52-15 EASTERN PROMENADE

Nov. 16, 1967

A check of your plans reveals that more information will be needed to show City of Ithaca Building Code compliance before permit for the superstructure of this building can be issued as follows:

RE: Portland House
45 Eastern Promenade

PROPOSED REVISION TO ADD
 ANOTHER MEANS OF EGRESS
 AT 1ST GARAGE LEVEL.

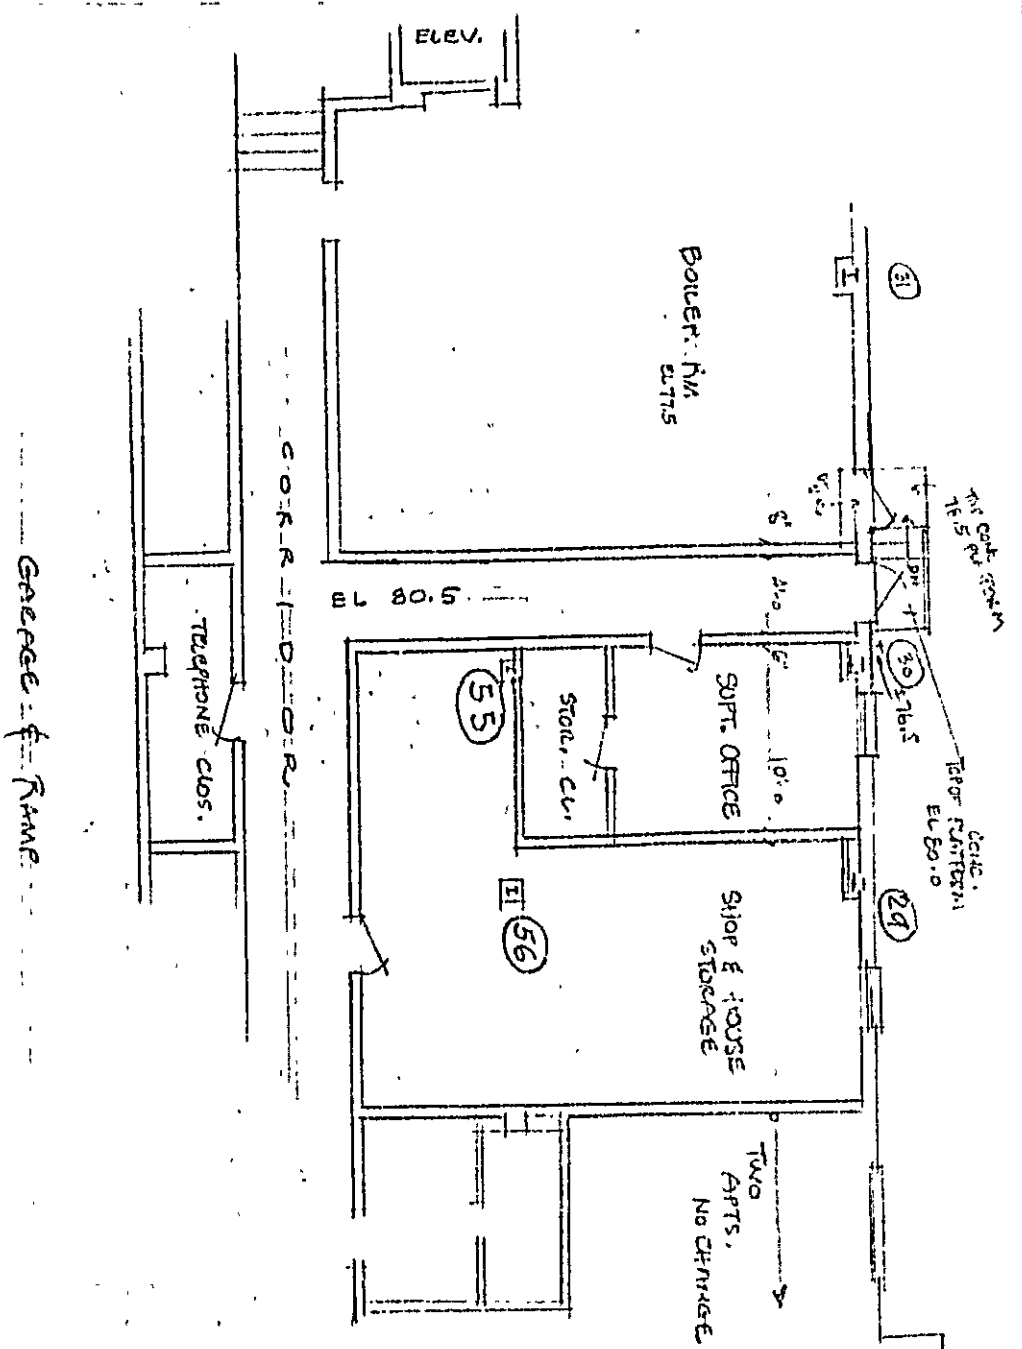
2. In order to comply with means of egress Section 402.5.1.4 stairwell number 2 will need to extend from the first garage level to the second garage level so that in case of an emergency persons can go directly out-of-doors at the ground level. The extension of the stairway and passageway to the exterior door will need to be closed off from the garage by two hour fire rated walls and Class B labeled doors with self closing devices. Any locking device on the exterior door will need to be of the vestibule latch set type. The function of this lock being that although locked from the outside can always be opened from within.

2. At our last meeting at your office on September 25, 1967, we made an analysis of the Code requirements pertaining to required exits from Garage levels # 1, # 2, and # 3. The only change indicated at the time was the elimination of a doorway from the 1st garage level to stairway No. 3 and, in lieu of that, the installation of a pedestrian door on the overhead garage door. Our plans now show this change.

In addition to the intercommunicating ramps, our plans now show two independent exits from each garage level either directly to the outdoors, or, as in the case of garage Vest. No. 2, into a fireproof corridor which in turn leads directly to outdoors. In our view, the extension of the stairwell No. 2 to garage level No. 2 will not in any way improve the exit facilities from this level. We respectfully, therefore, ask that you reconsider your request stated in par. 2. of your letter

TYPICAL DETAIL AT
SPANDREL BEAM

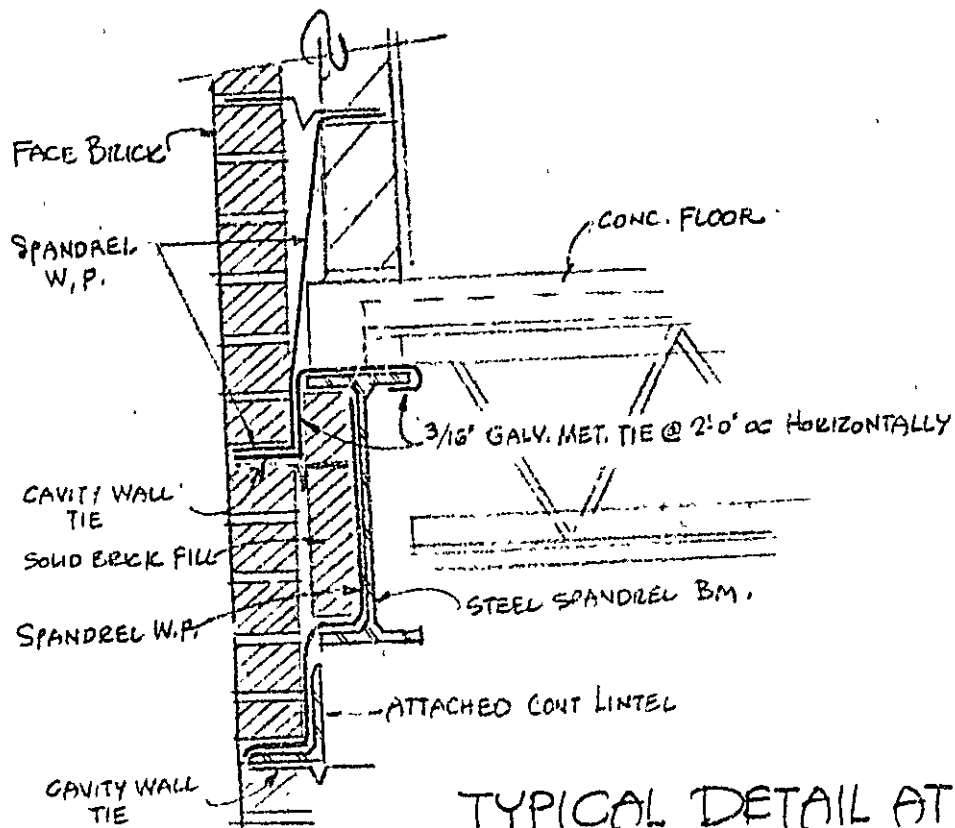
4. The face brick will need to be tied to the concrete block backing and the spiral steel by approved 3/16 diameter galvanized wire lap ties at every fifth joint vertically and at not over 2 feet o.c. horizontally. These ties may be of the adjustable type. Continuous track or ladder type concrete block reinforcing is not approved for tying the brick facing to the concrete block backing.

4. Following Federal Specifications and general practice our specifications Page 5A-10-E-1 calls for $\frac{1}{4}$ " or $\frac{3}{16}$ " "Z" type galvanized iron or zinc alloy ties spaced 30" horizontally and 16" vertically. We enclose herewith copy of a sketch also showing said "Z" type tie. The sketch also shows $\frac{3}{16}$ " galvanized steel tie at the spandrel beam as per your oral request. We trust that this meets with your approval.
